Your Ref 2025/92882

**Proposal: Erection of 75 dwellings with associated parking, infrastructure, hard and soft landscaping and access from Manchester Road**

**Location: Cellars Clough Mill, Manchester Road, Marsden, Huddersfield**

**Waterway: Huddersfield Narrow Canal**

proposed plan 1:250 showing new access from towpath through to site entrance road & new (re-used stone) steps up to existing footbridge

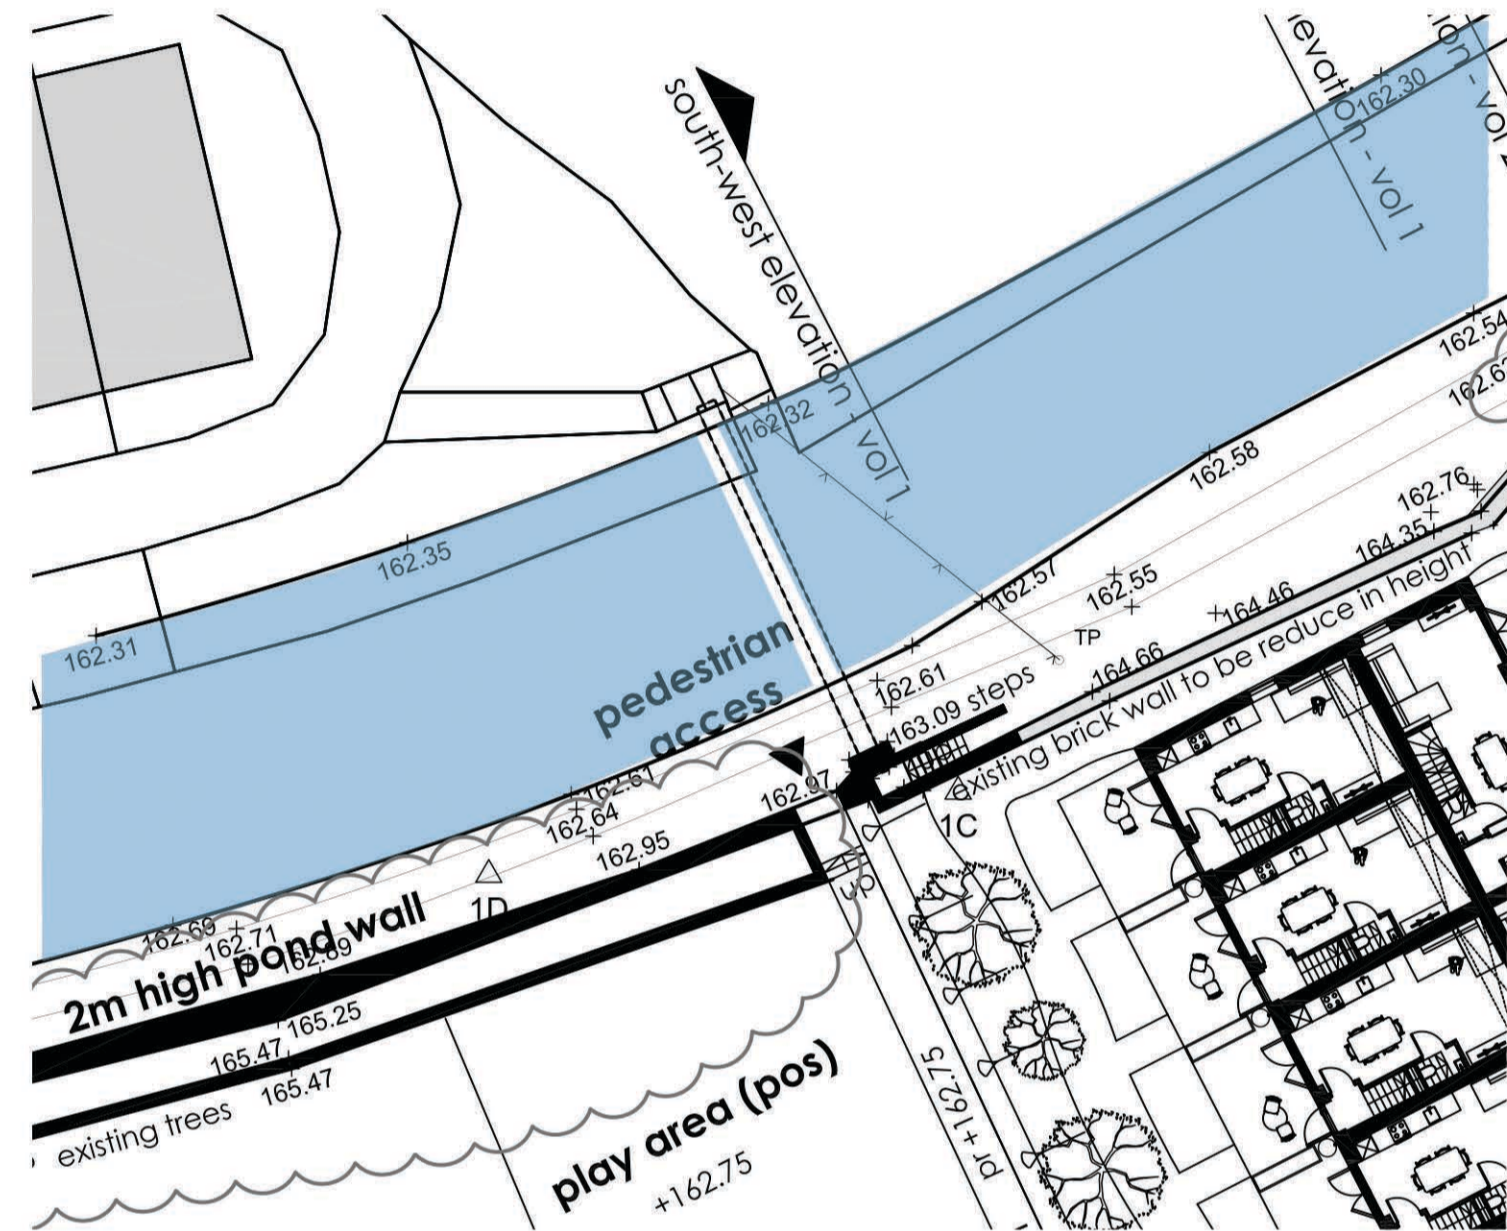
The formation of a new pedestrian connection to the canal towpath, as shown, would require the consent of the Trust in our capacity as landowner. Any new right of access over the canal, or our landholding in general would be subject to an easement being acquired by the developer from the Canal and River Trust. Our estates section can be contacted via switchboard on 0303 040 4040 for further information.

north-west elevation to canal & towpath 1:250

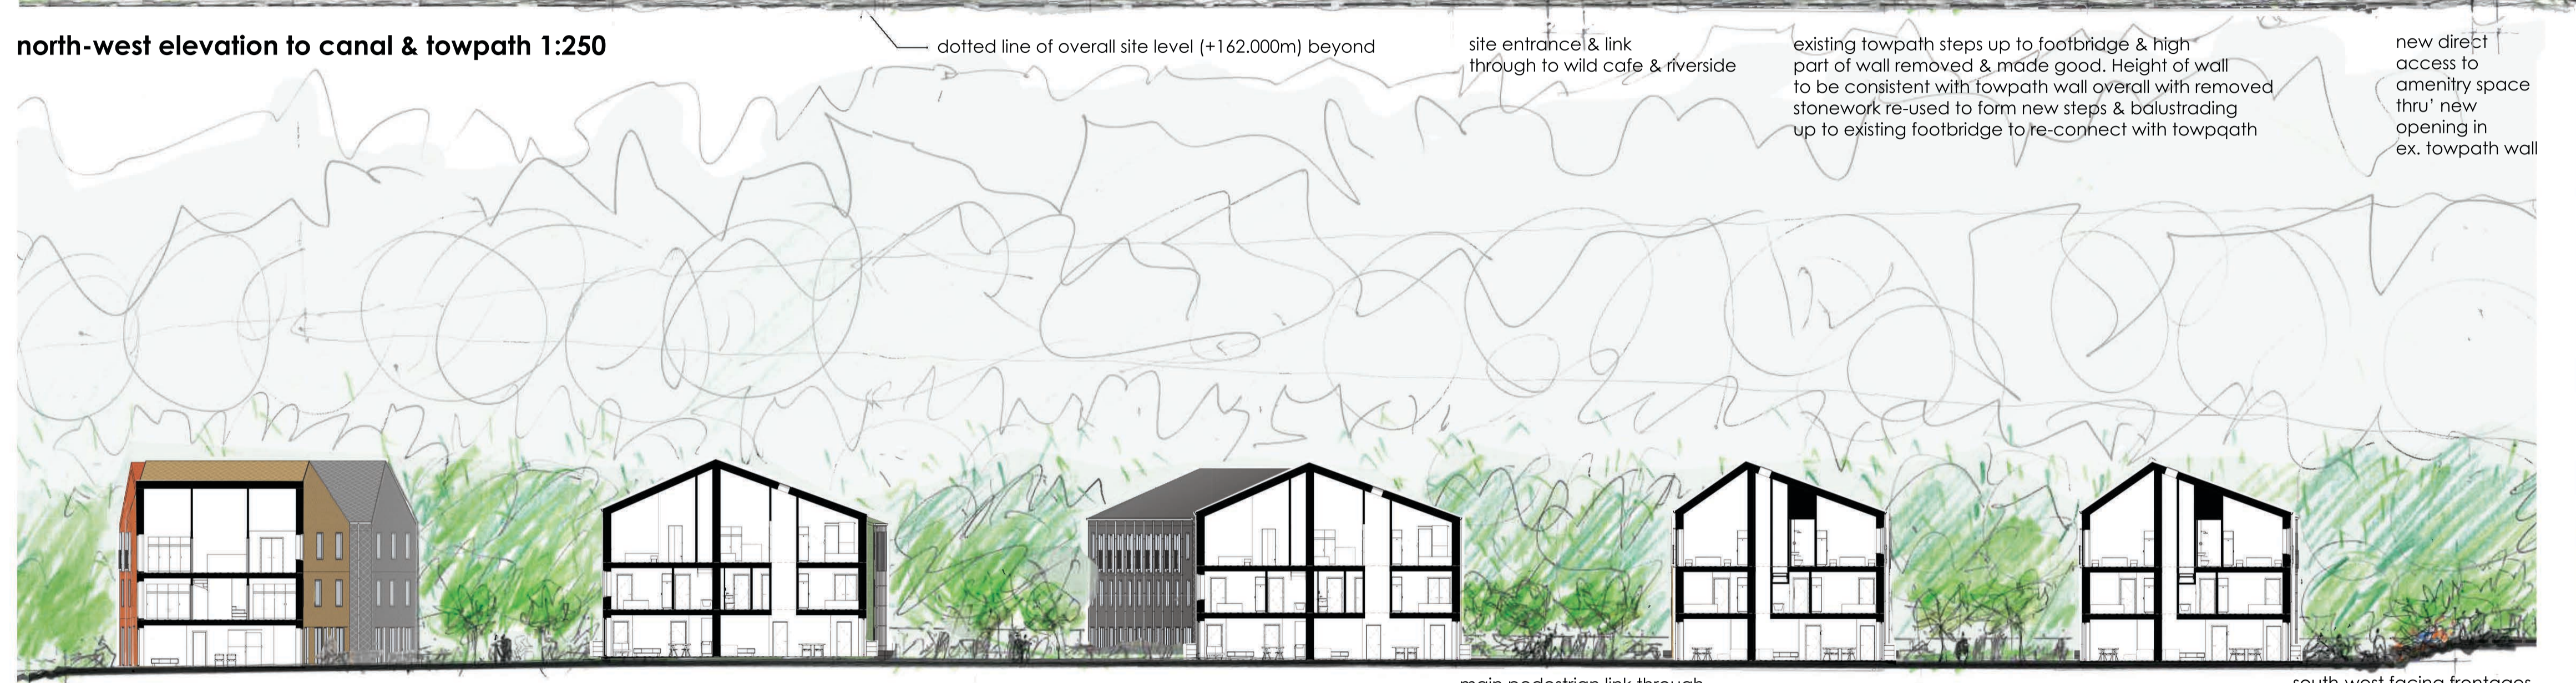
The orientation of the proposed development would feature the gable end of dwellings facing the canal, which would limit the level of engagement between the development and the waterway. We therefore request that, if possible, consideration should be given towards the re-orientation of the properties so that principal elevations face towards the canal, which would help provide an improved degree of and would also help improve engagement between the development and the waterway corridor.

Appendix F – Drainage Strategy

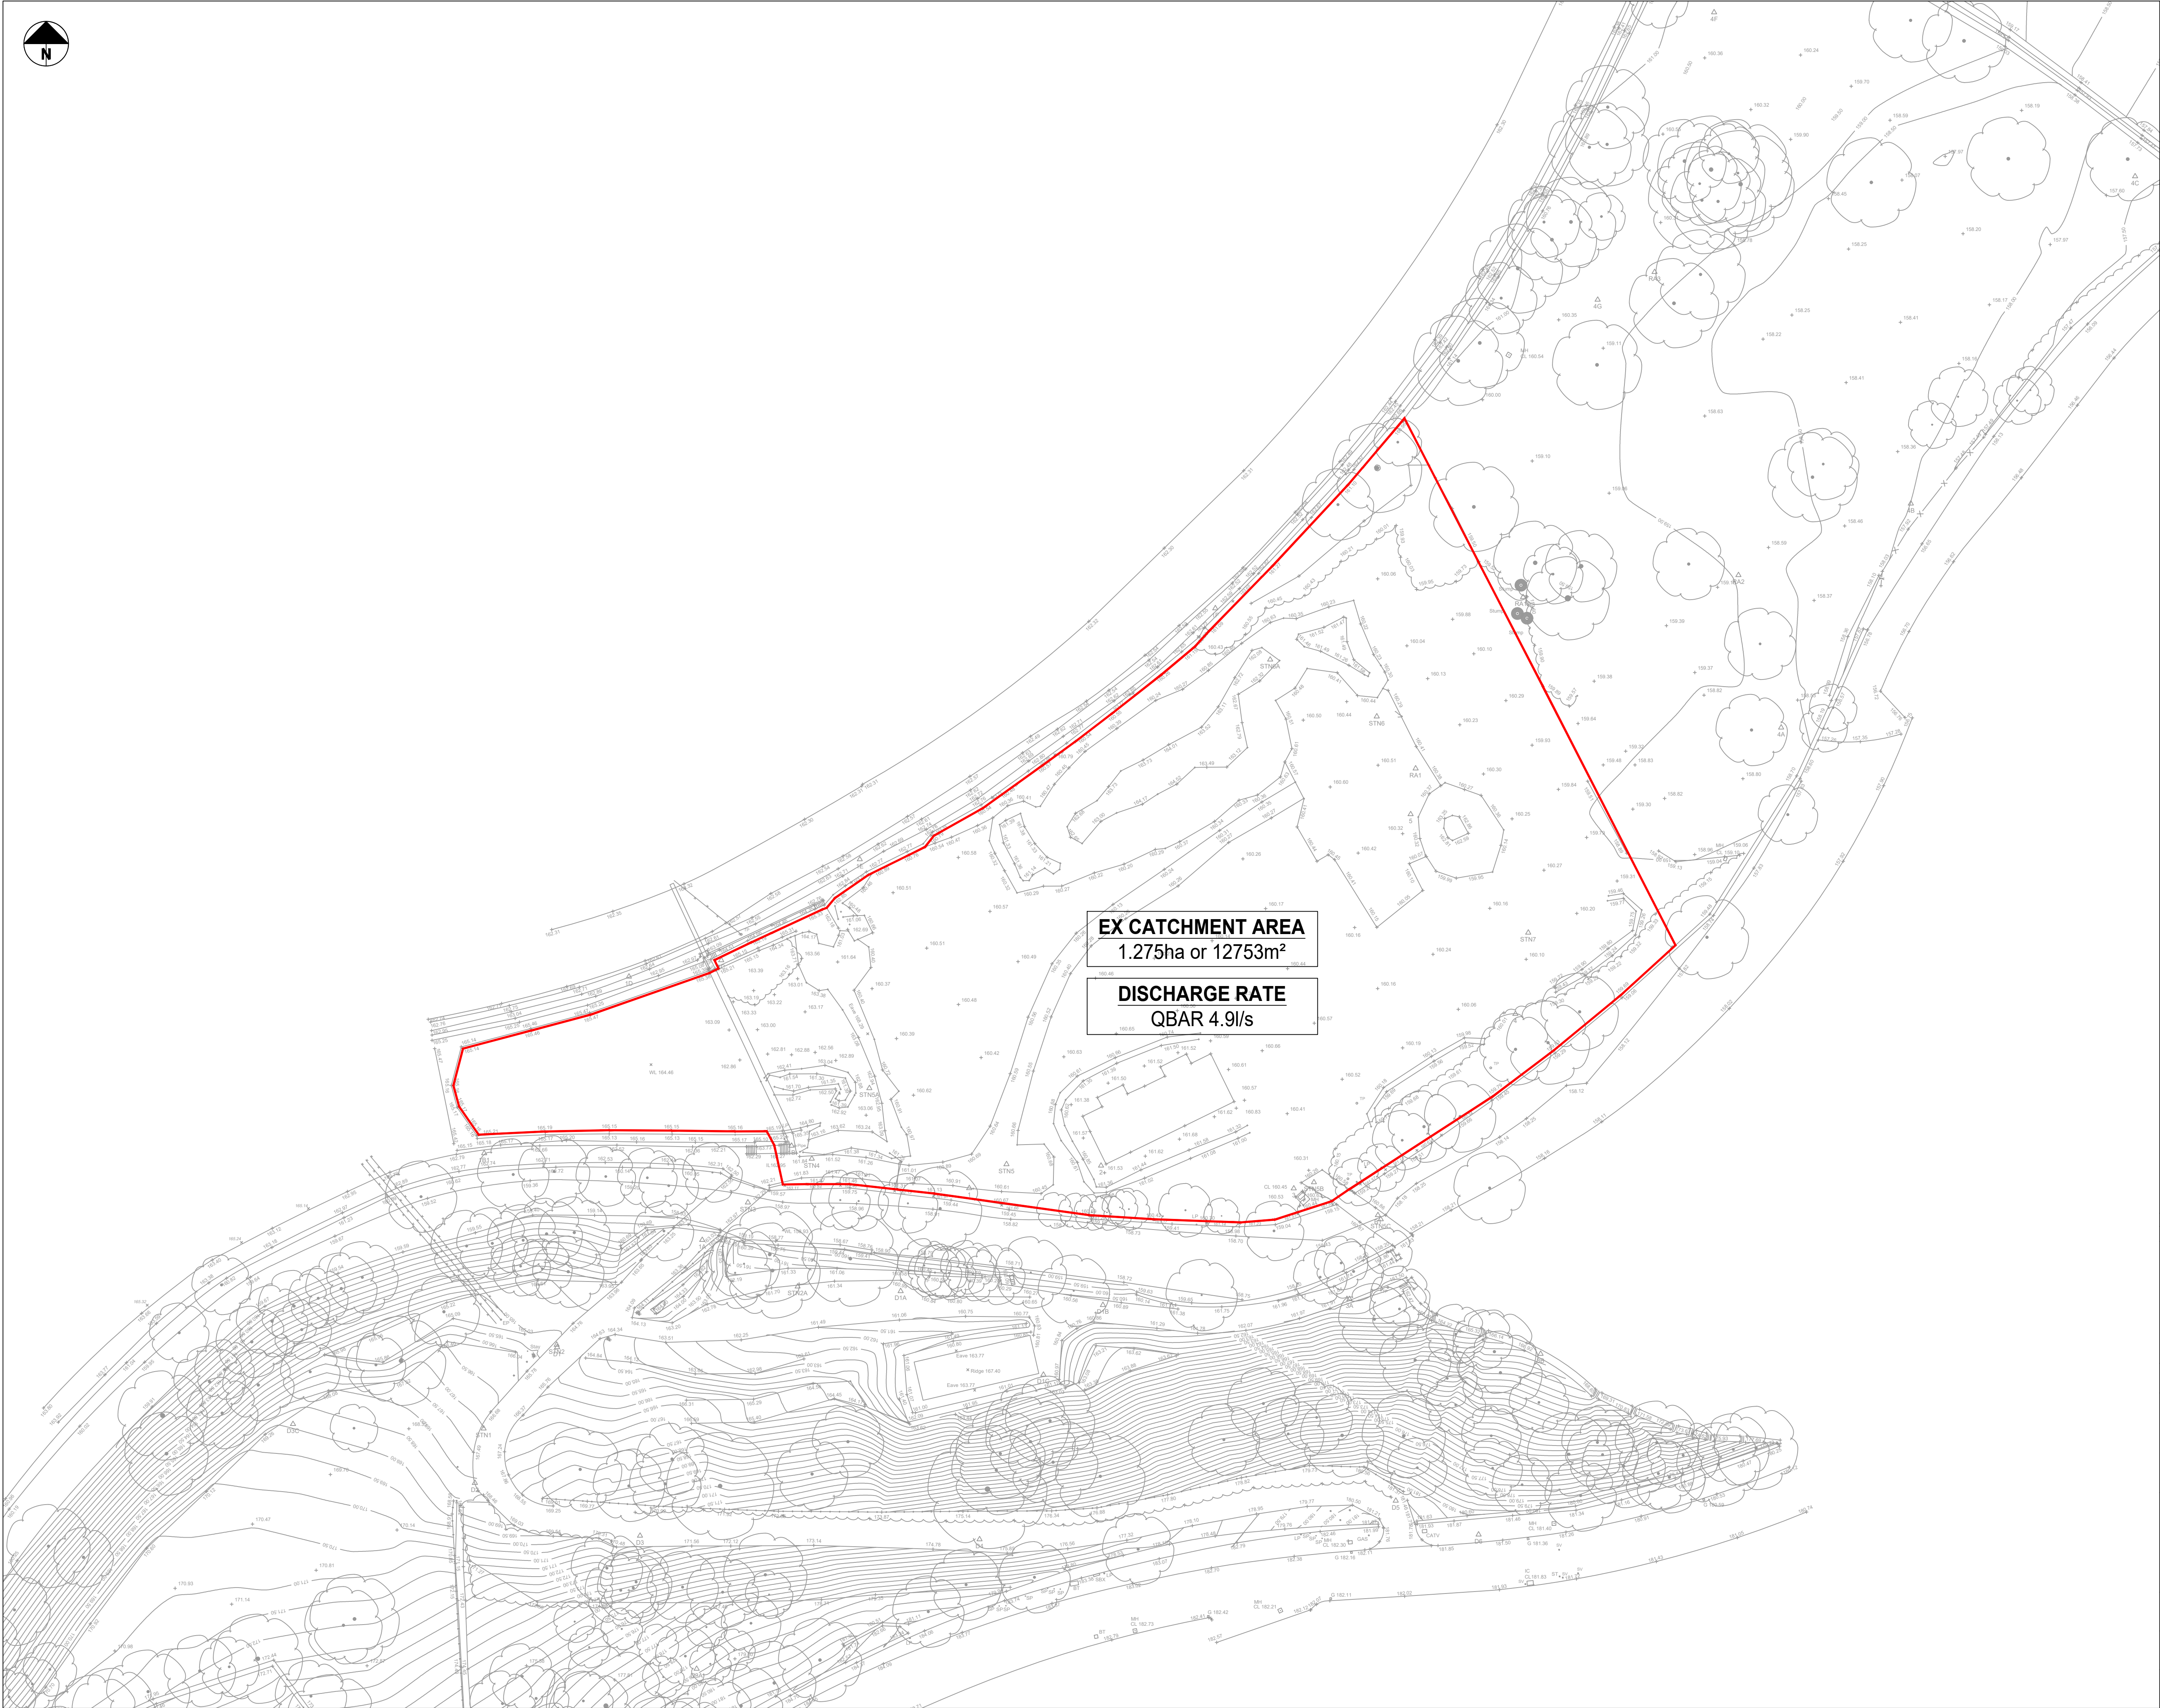
The proposals seek to discharge surface water via a connection to the culvert that takes water from Sparth Reservoir to the River Colne. It is essential to ensure that appropriate capacity exists within the culvert to accommodate additional surface water drainage from site. Should there be insufficient capacity, then this could impact the ability to manage water flows on Sparth Reservoir, which could adversely impact public safety and residual flood risk. We therefore request that **full details of the capacity of the existing culvert and its**

capacity to accommodate future flows from the site in addition to the existing flow from Sparth Reservoir should be provided to confirm that a safe connection can be made prior to this detail being fully approved.

Final surface water drainage details could be reserved through the use of appropriately worded planning condition(s).
